Demolition of existing garage & store on existing dwelling & construction of 2 new dwellings in rear garden.

6 Manor Road Rustington

Thank you for your internet representation made on 7th May 2019 which has been recorded as '**an objection**' with the comments as follows:

DRAWING: PROPOSED NEW DWELLINGS - PLANS **SCALE:** 1:50 @ A2 **DATE:** 24/04/2019 **DRAWING No:** DS/6MANOR/04 rev 1

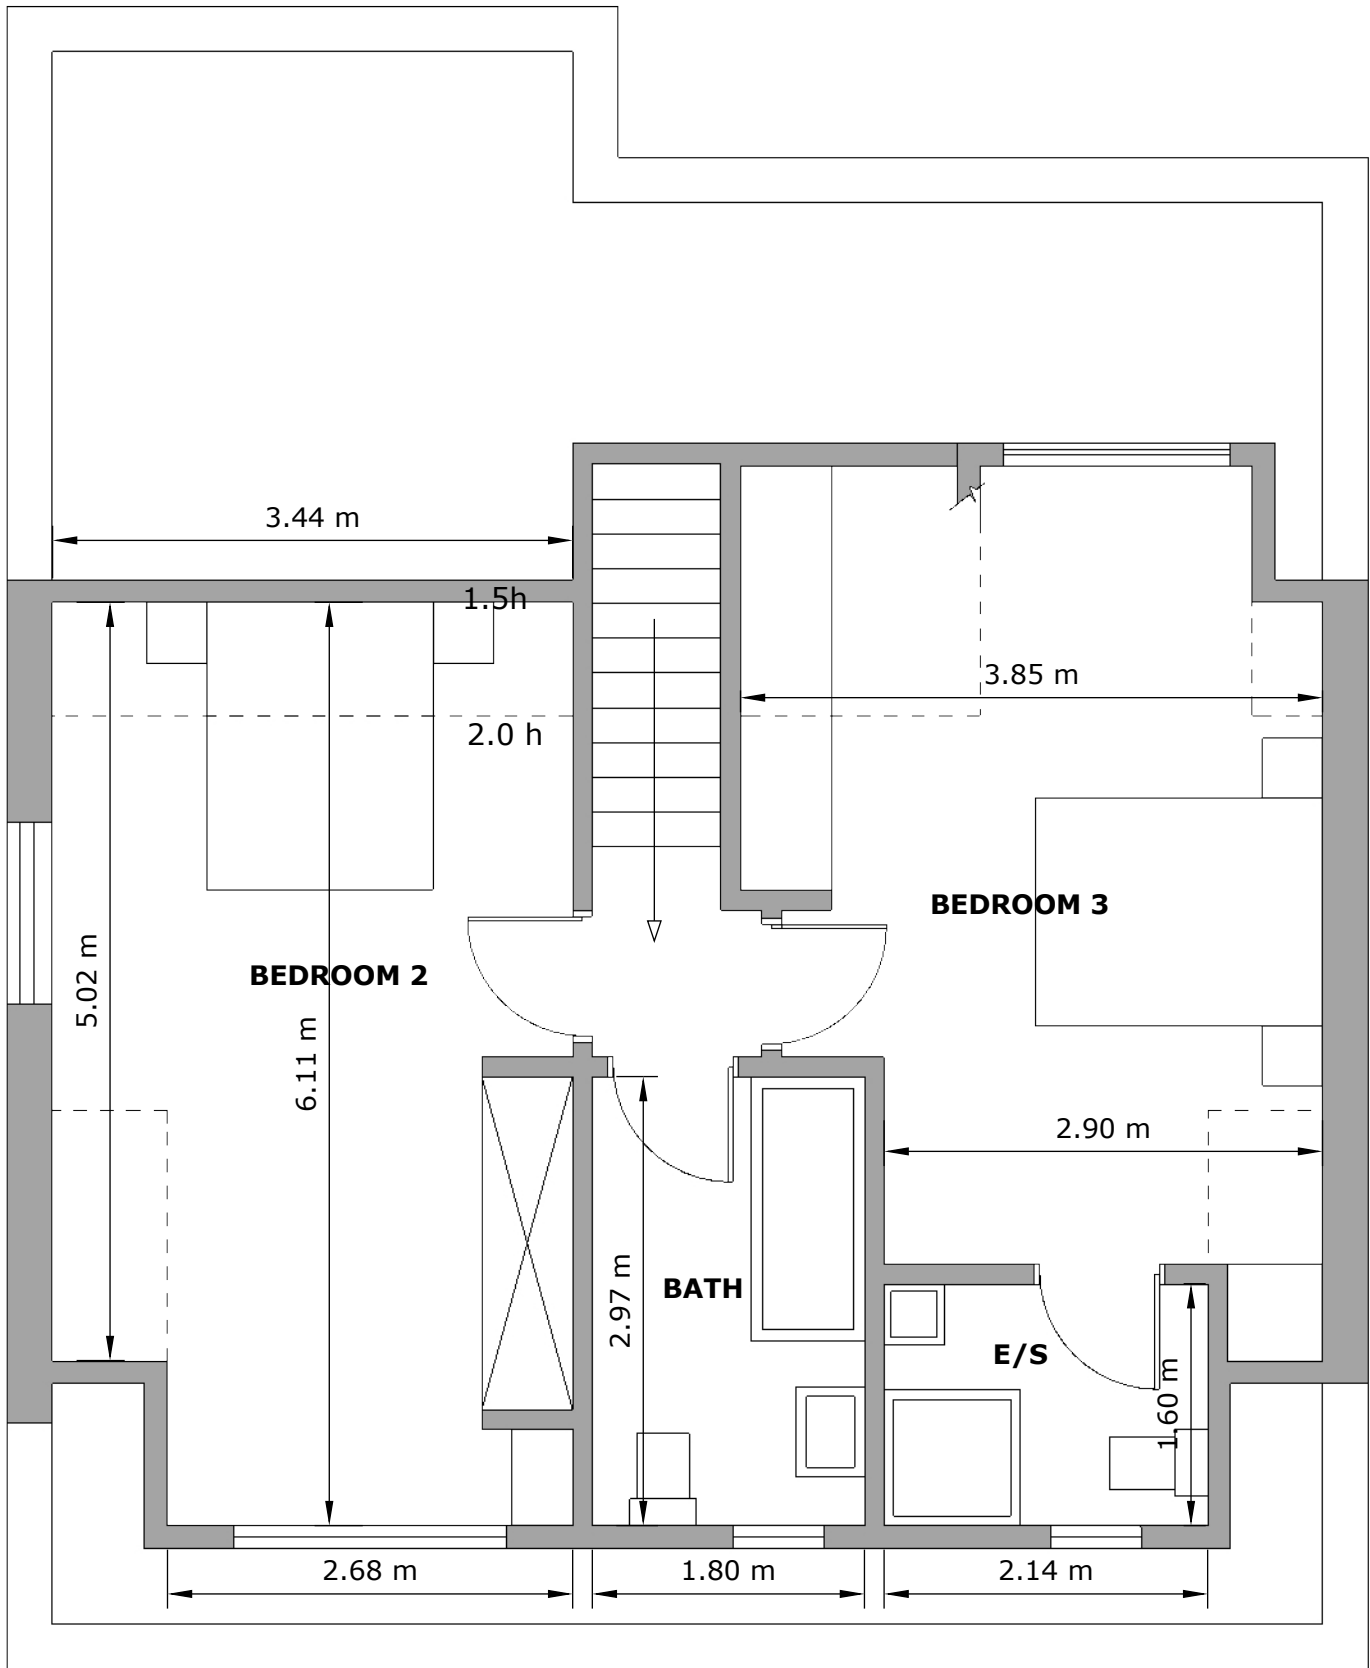
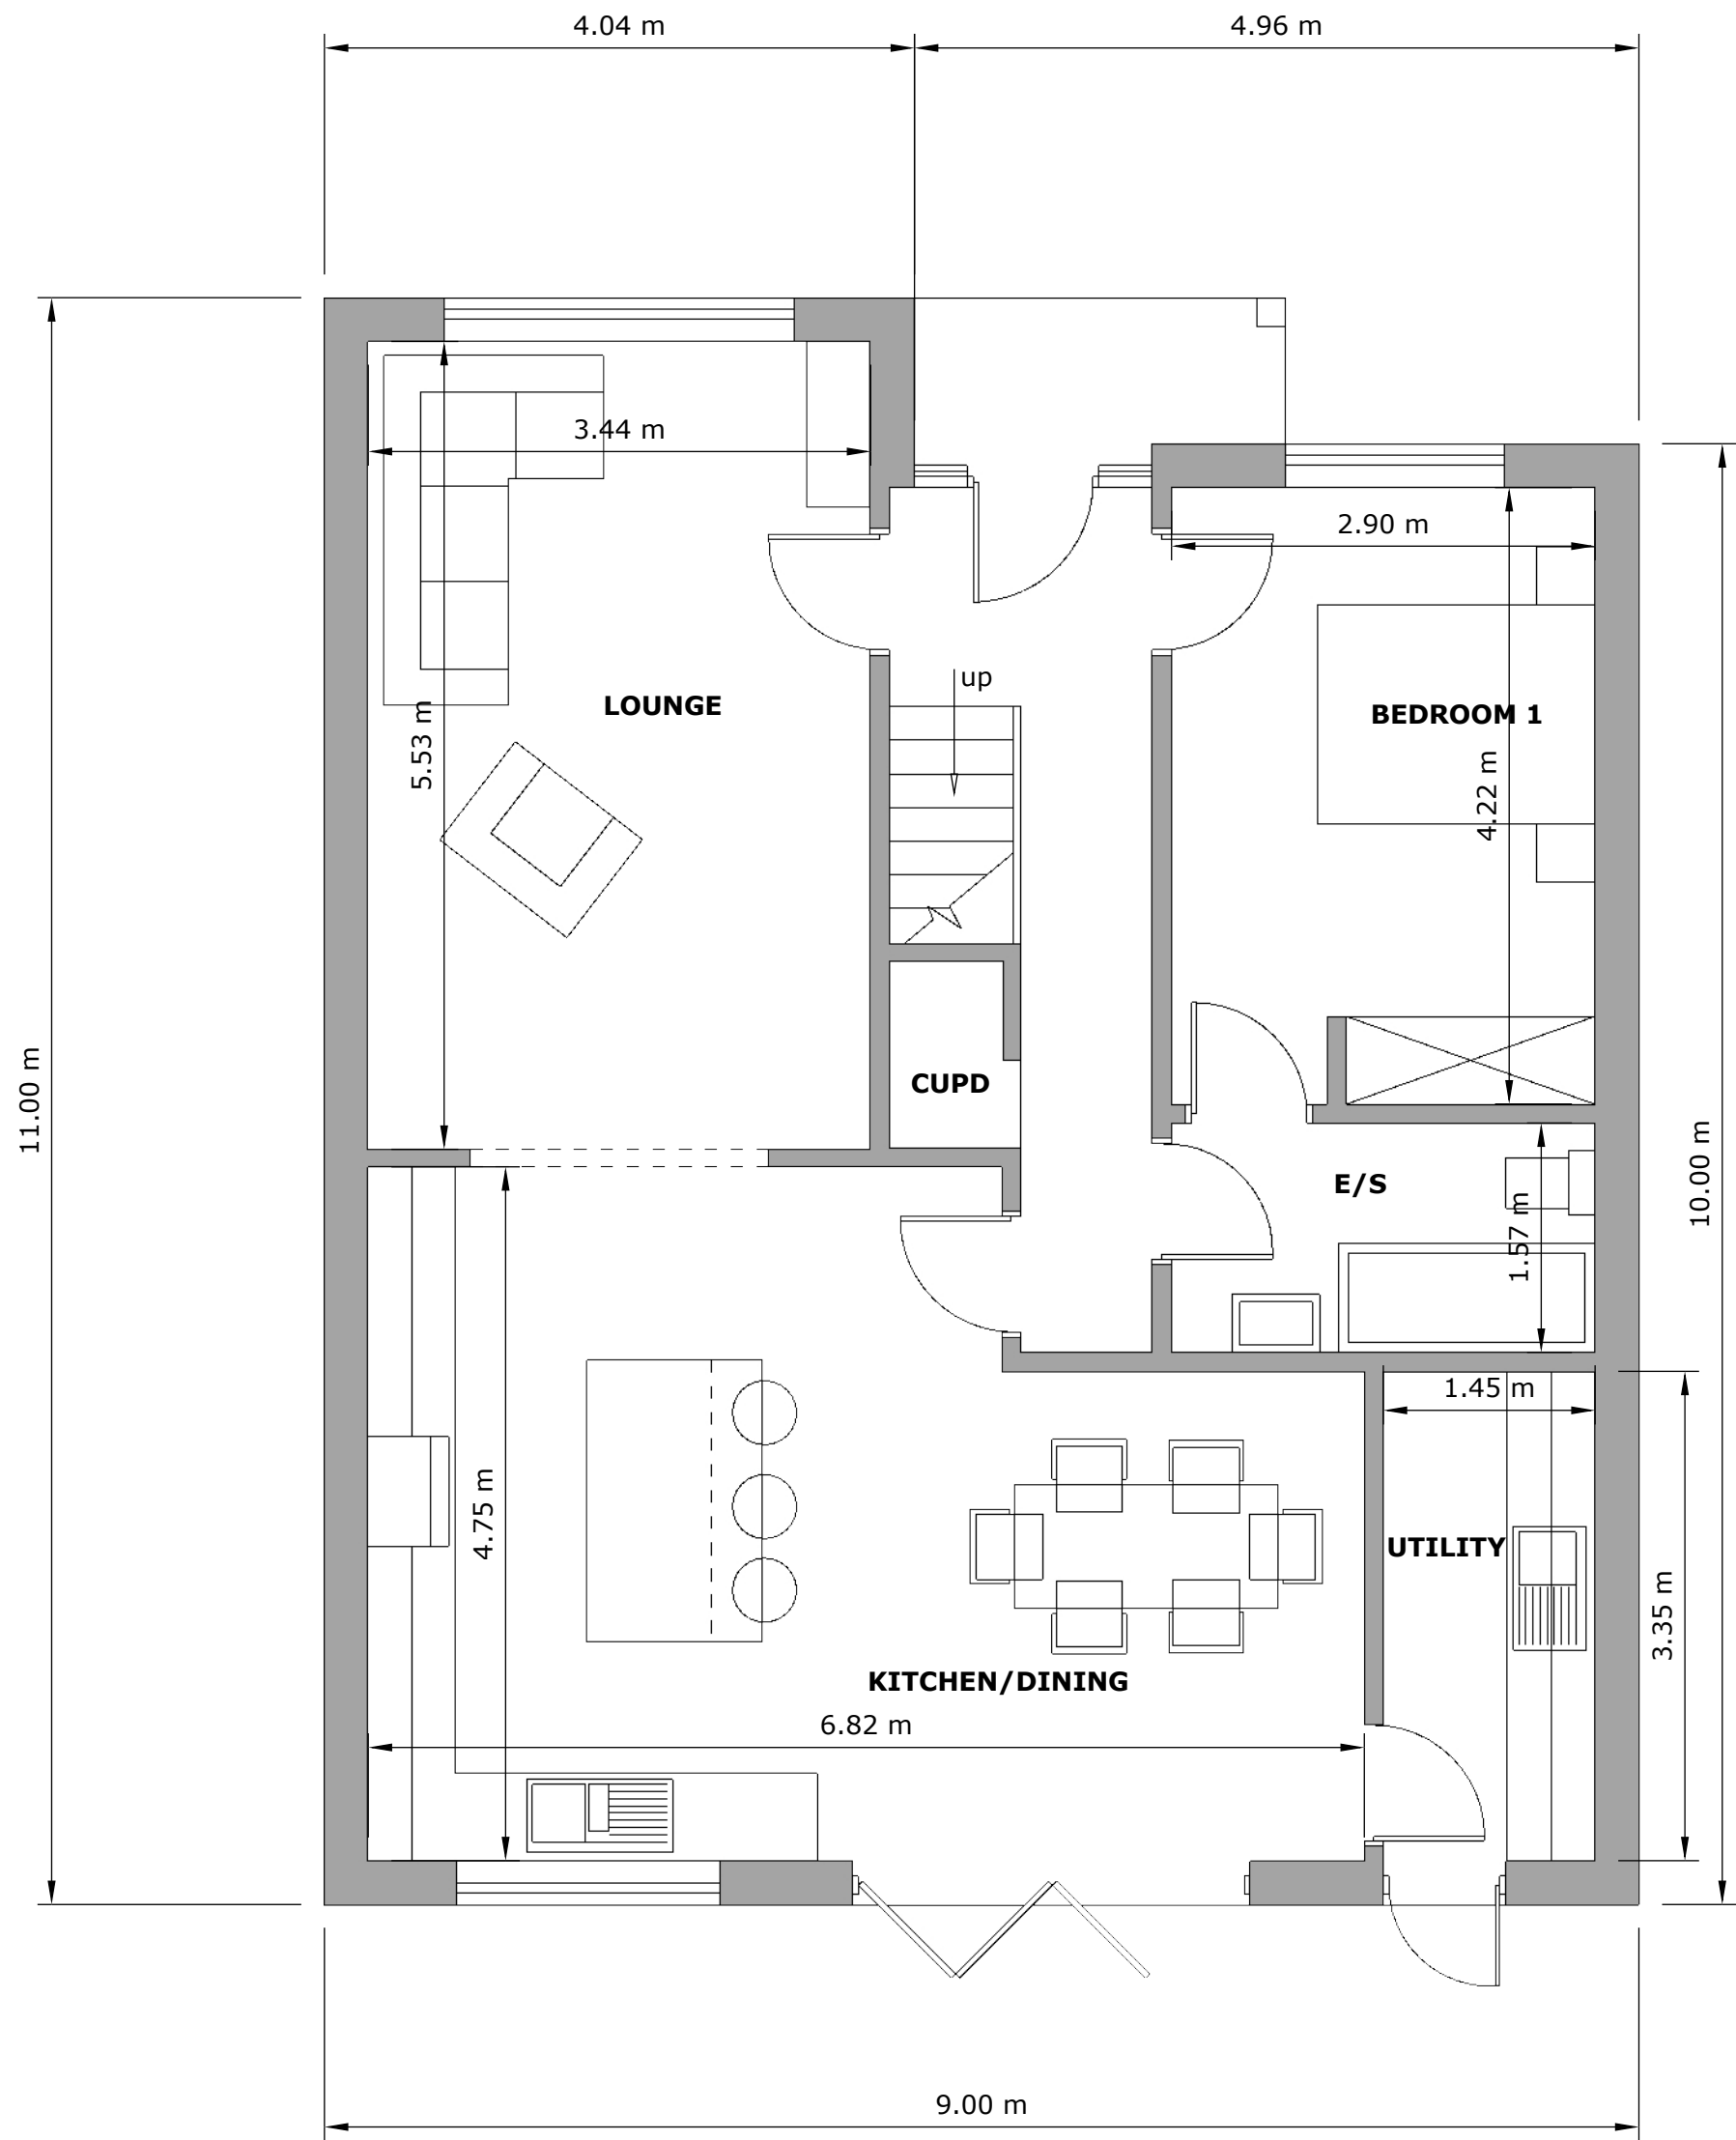
We have reviewed the amended drawings and there still appears to be a discrepancy between the plans and elevations. The front elevation shows the plots mirrored like the site plan, however the back elevation is not mirrored. The plot furthest from us looks correct but the one nearest us is a repeat of the other plot. Is this correct or should the back elevation be mirrored to match the floor plans? We have been led to believe on the back we could be overlooked by two small bathroom windows when in fact it looks like it could be the main bedroom.

We see the first floor bedroom window now added to the side elevations overlooking us. Is this necessary with the main bedroom having a large window looking onto the back garden.

DRAWING No: DS/6MANOR/03 rev 1

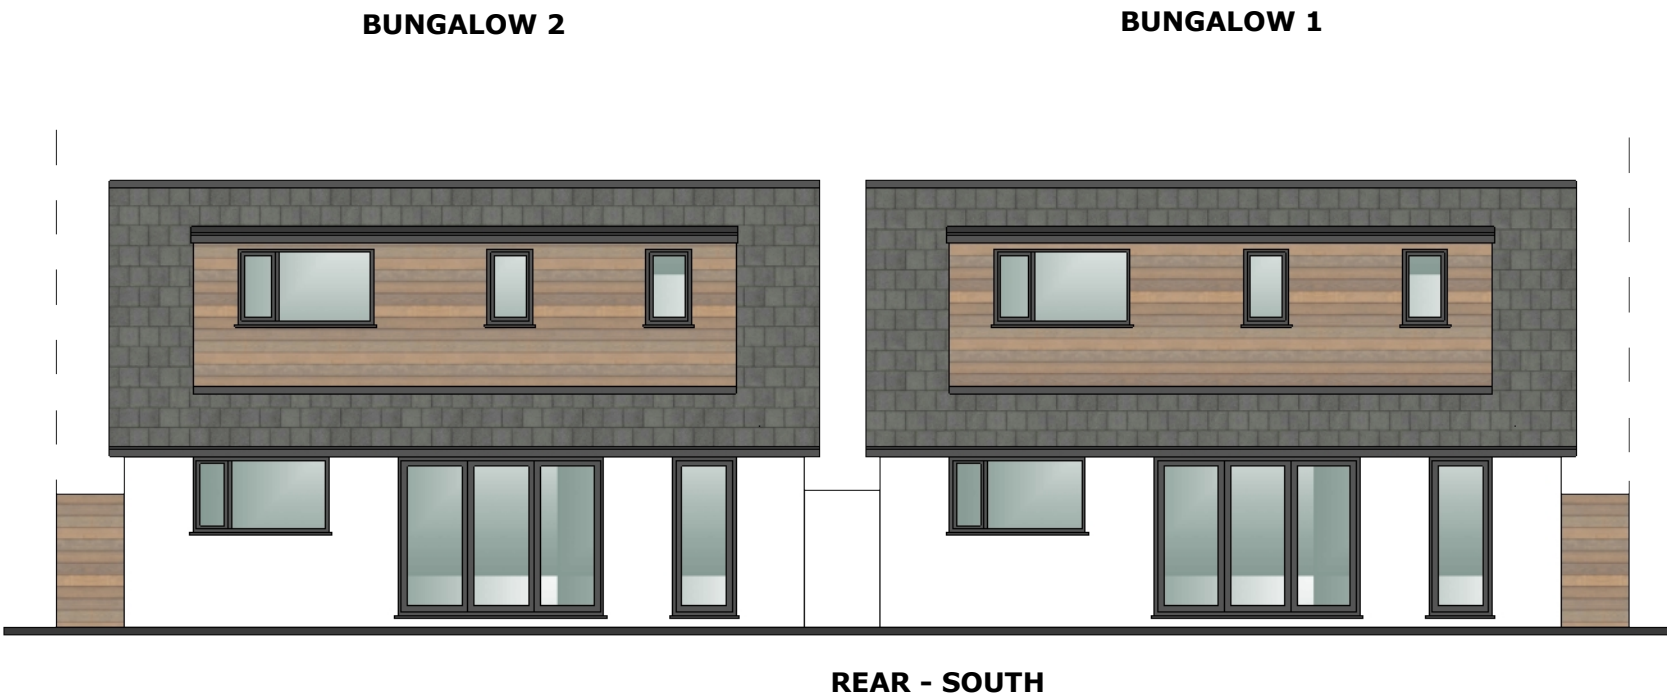
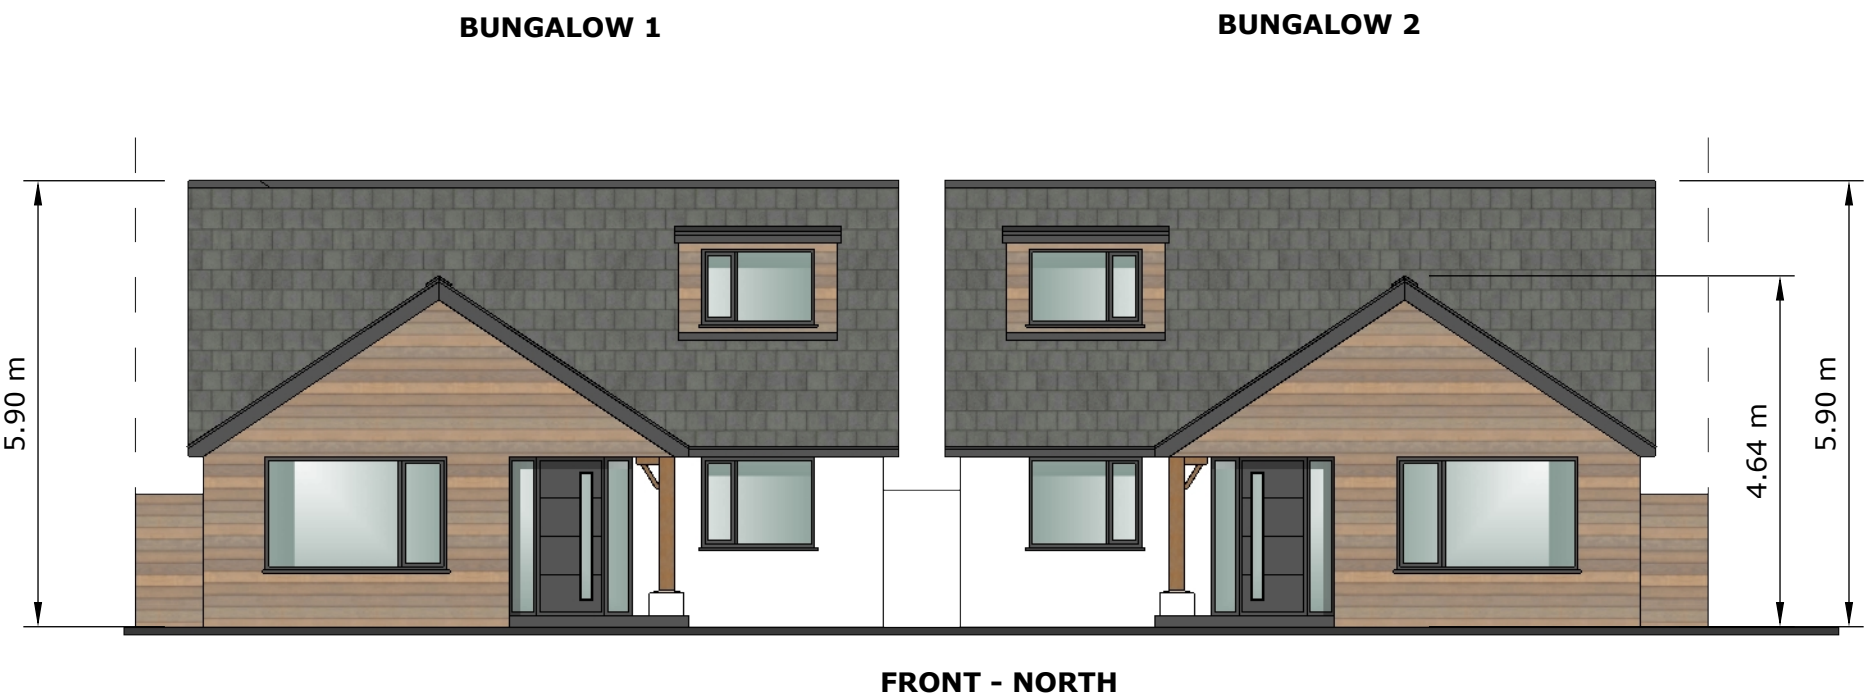
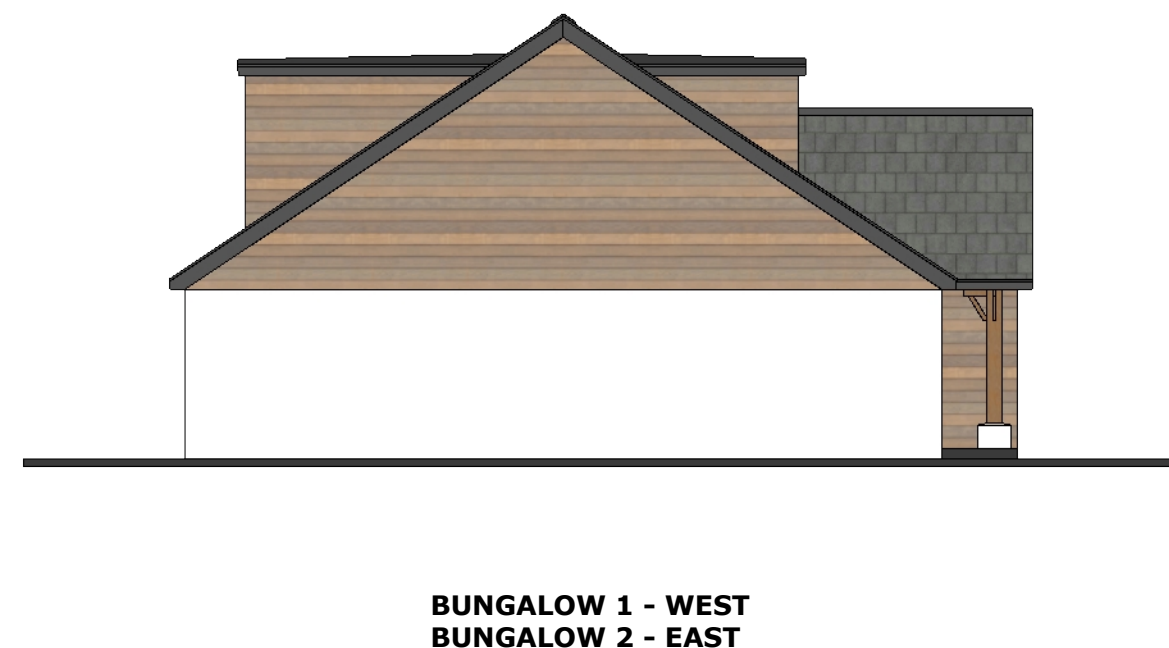
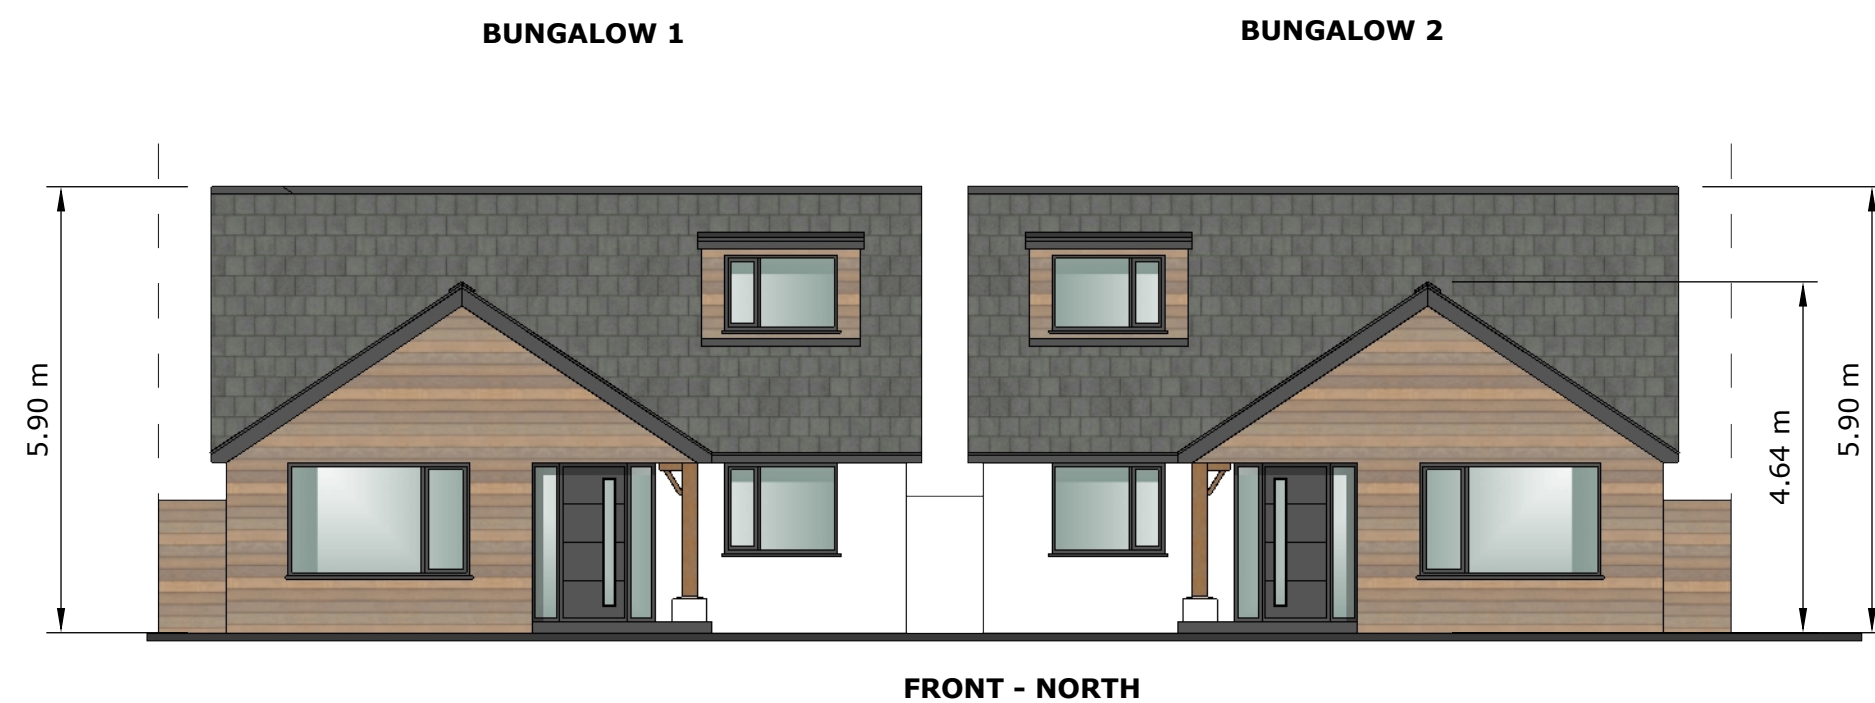
We see the ridge height has been reduced to 5.9m, however the ridges are still around 0.95m higher than the adjacent bungalows of Grafton Close. Our bungalow ridge height is 4.95m but we believe the new street scene shows our height at 5.15m when scaling the drawings, which is incorrect.
